KITTITAS COUNTY FIRE MARSHAL'S OFFICE

Fire Marshal comments

Project Name Horizon Towers

Case Number ACU-24-00001

TITLE
SITE PLAN

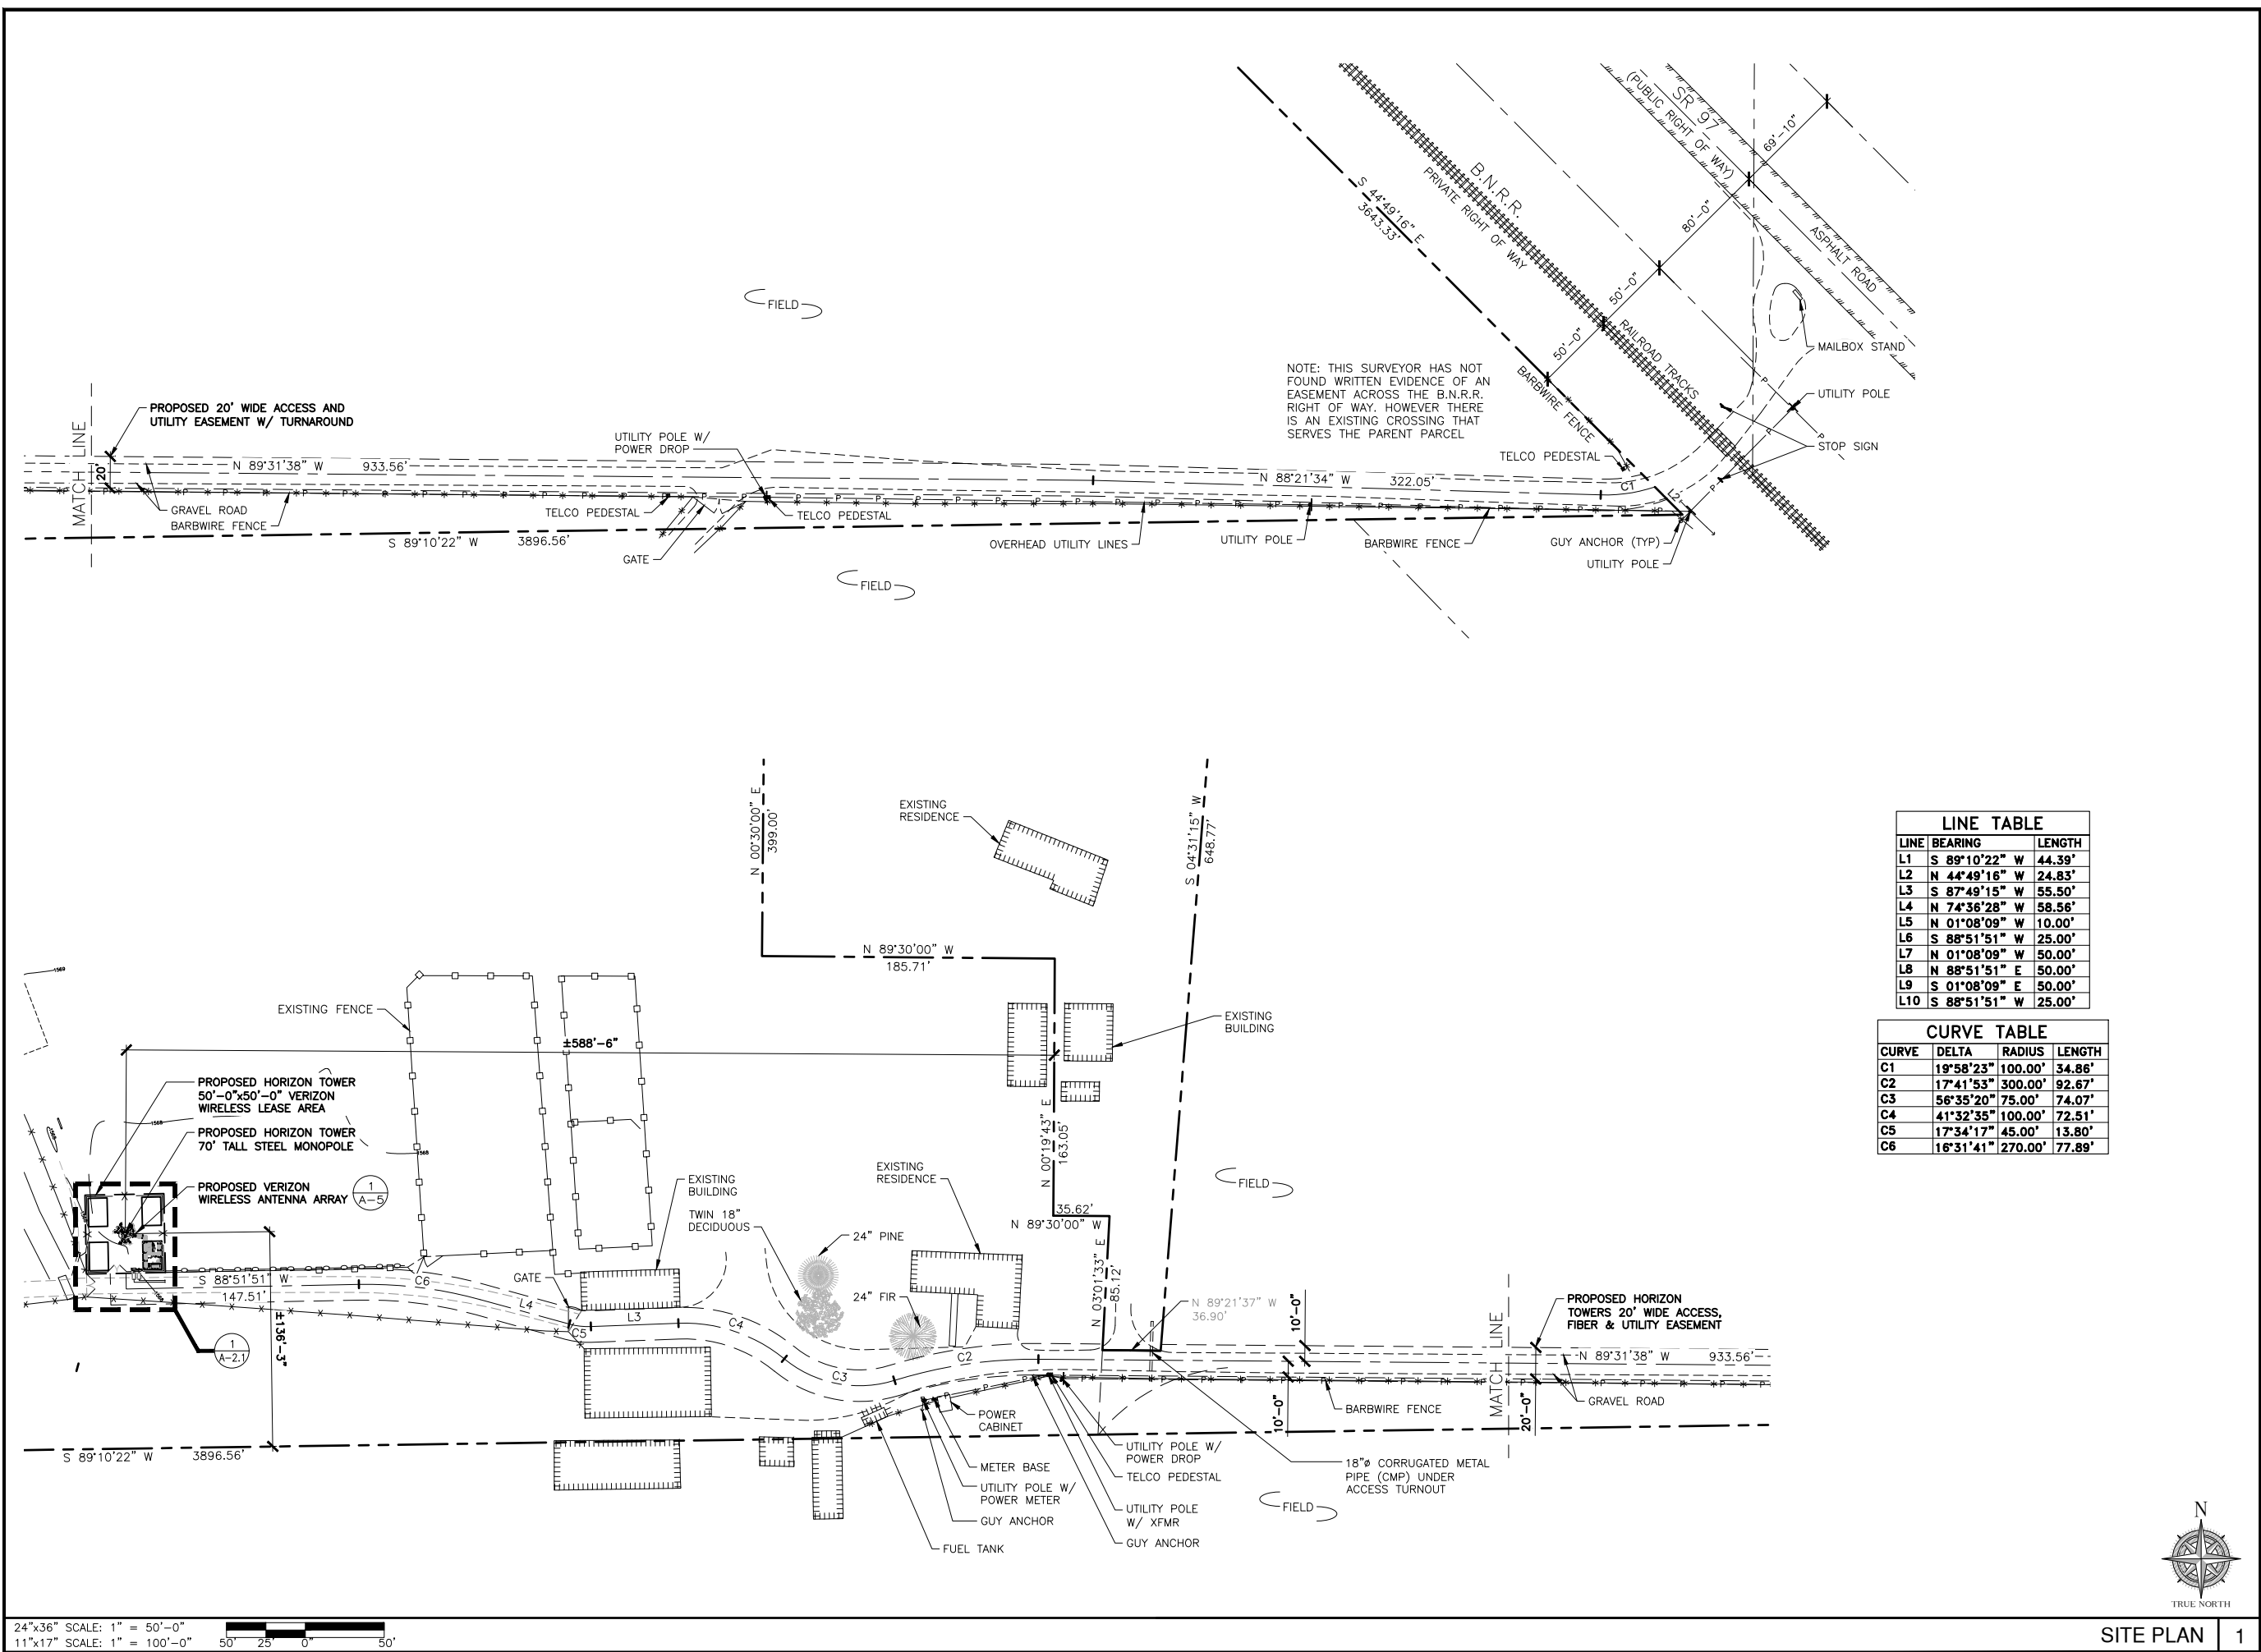
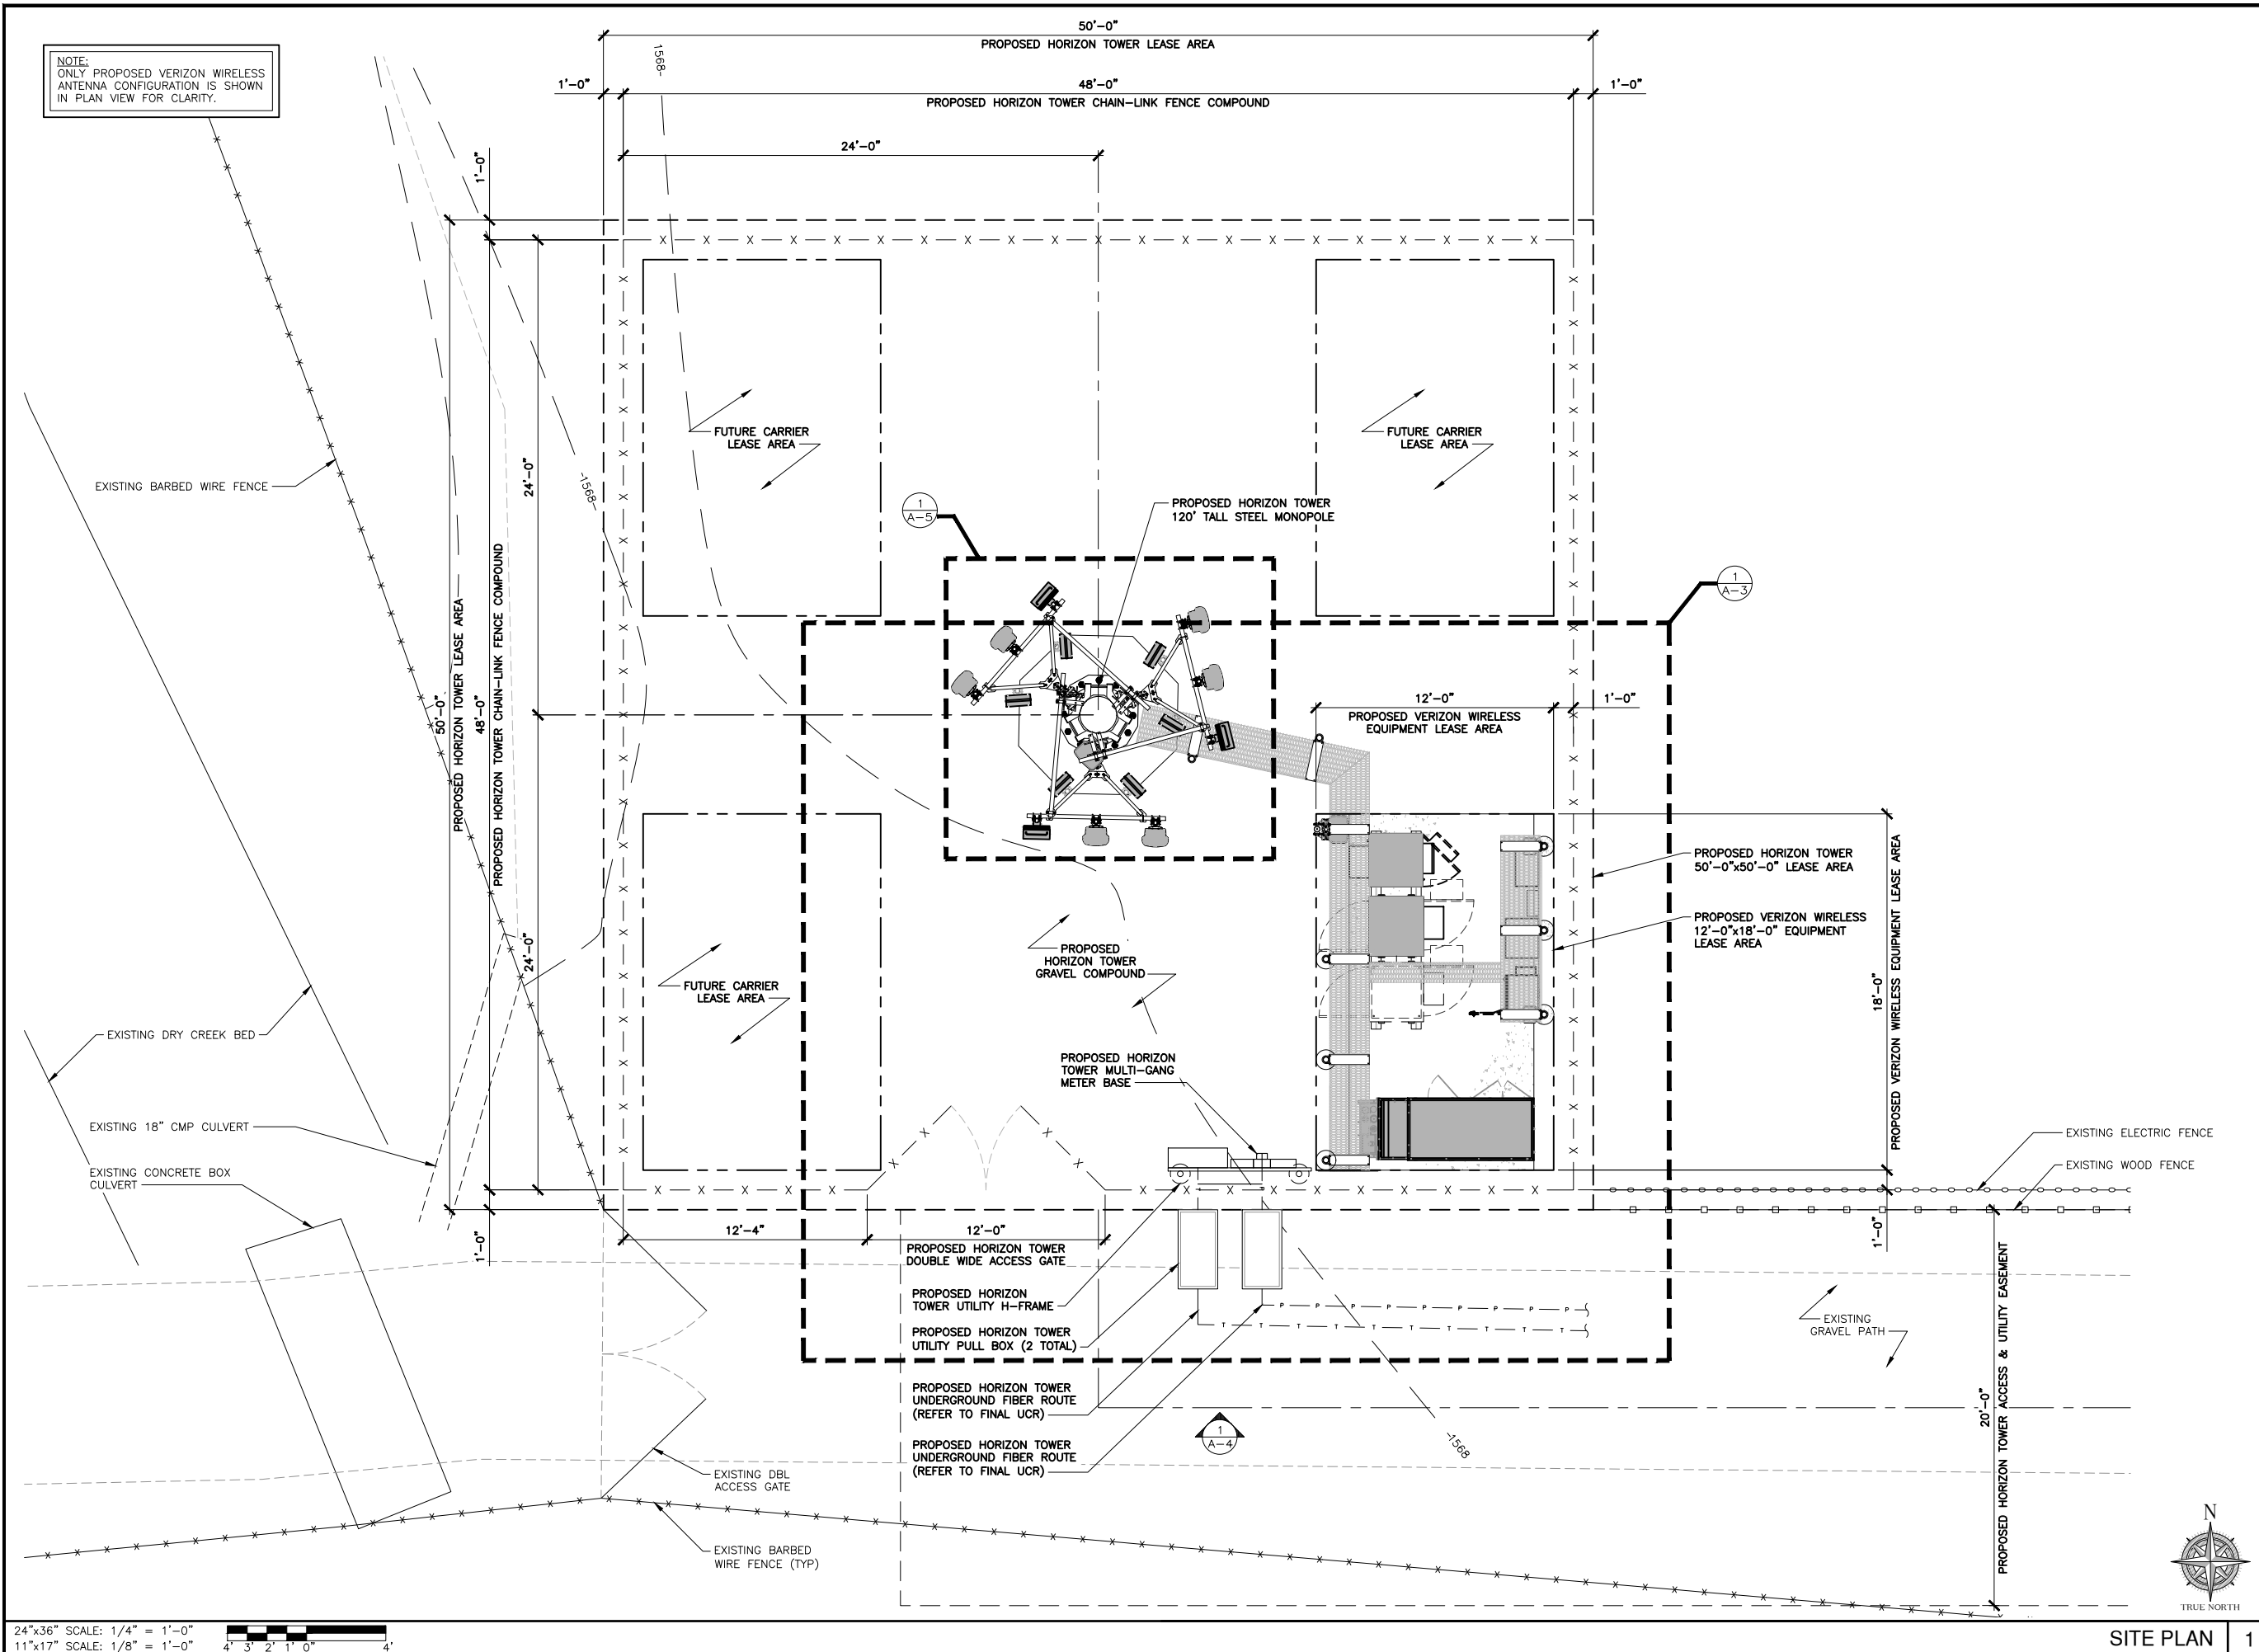
Fire apparatus access is required for this application. Provide fire apparatus access roads with an unobstructed width of not less than 20 feet, an unobstructed vertical clearance of not less than 13.5 feet, with an all-weather driving surface and capable of supporting the imposed loads of fire apparatus. Access roads shall extend to within 150 feet of all portions of the facility and all portions of the exterior walls of the first story of the building. Roads constructed in grades steeper than fifteen percent (15%) shall be constructed with Portland cement concrete with grooved surfacing.

Approved fire apparatus turnarounds are required for this project.

No gate may be installed across a required fire department access road or driveway without first obtaining a permit from the fire marshal's office. Inspection and testing of the gate will be required.

Proposed generator will require review and permitting through the fire marshal's office. A final inspection will be required.
